Response to Submissions

Waterloo Metro Quarter – Northern Precinct (SSD-79307758)

March 2026

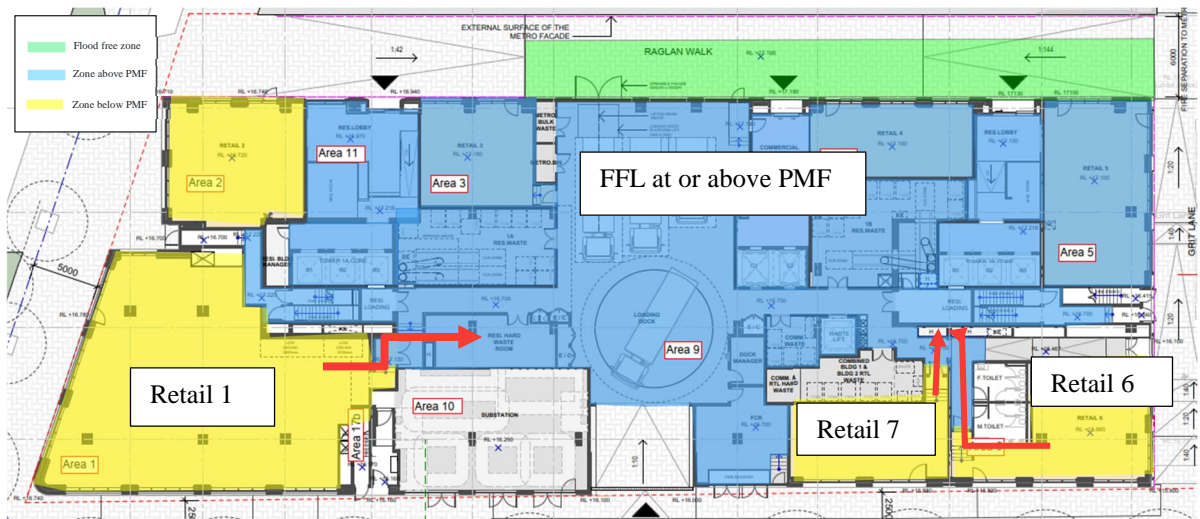
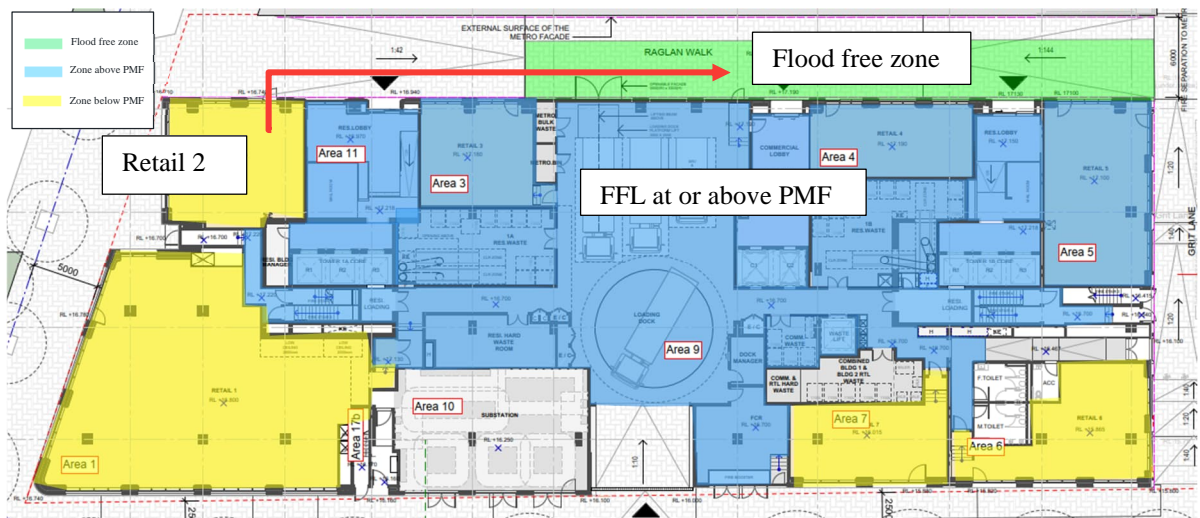
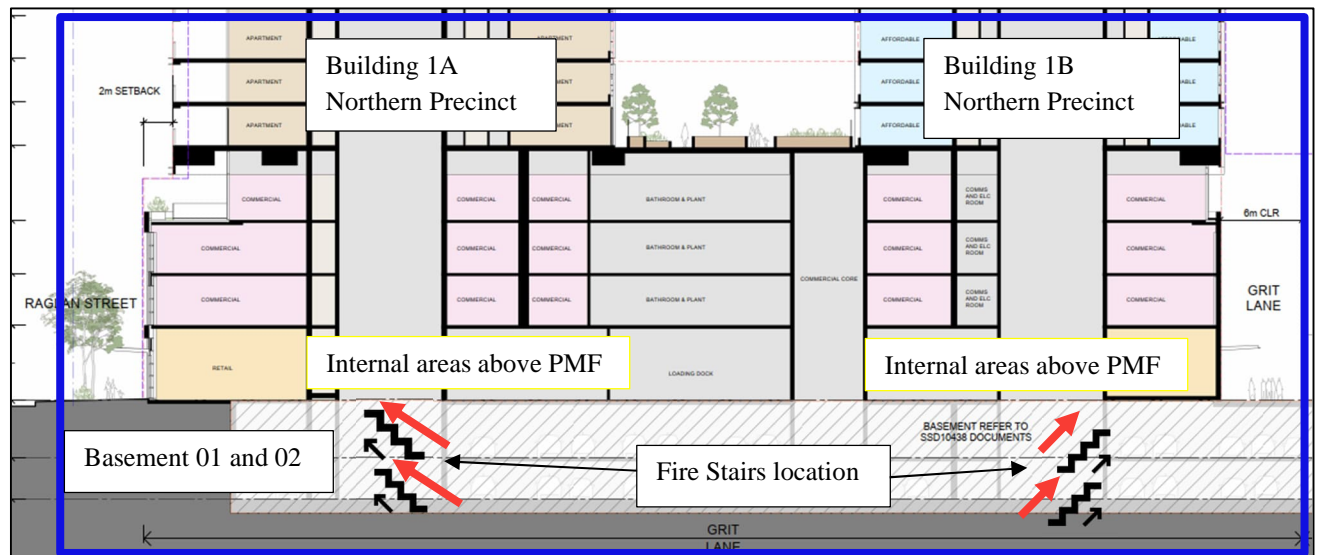
d) Submit revised emergency management and evacuation strategy detailing approach for occupants that need to relocate to on-site shelter, including the basement and details on the emergency management for the childcare centre	Emergency Service has commenced and will continue as part of the refinement of the Flood Emergency Response Plan.
e) Any emergency management and evacuation strategy should be prepared in accordance with the Shelter-in-Place Guidelines for Flash Flooding and in consultation with NSW SES.

A Flood Emergency Response Plan will be prepared and implemented prior to occupation. Engagement with the NSW State
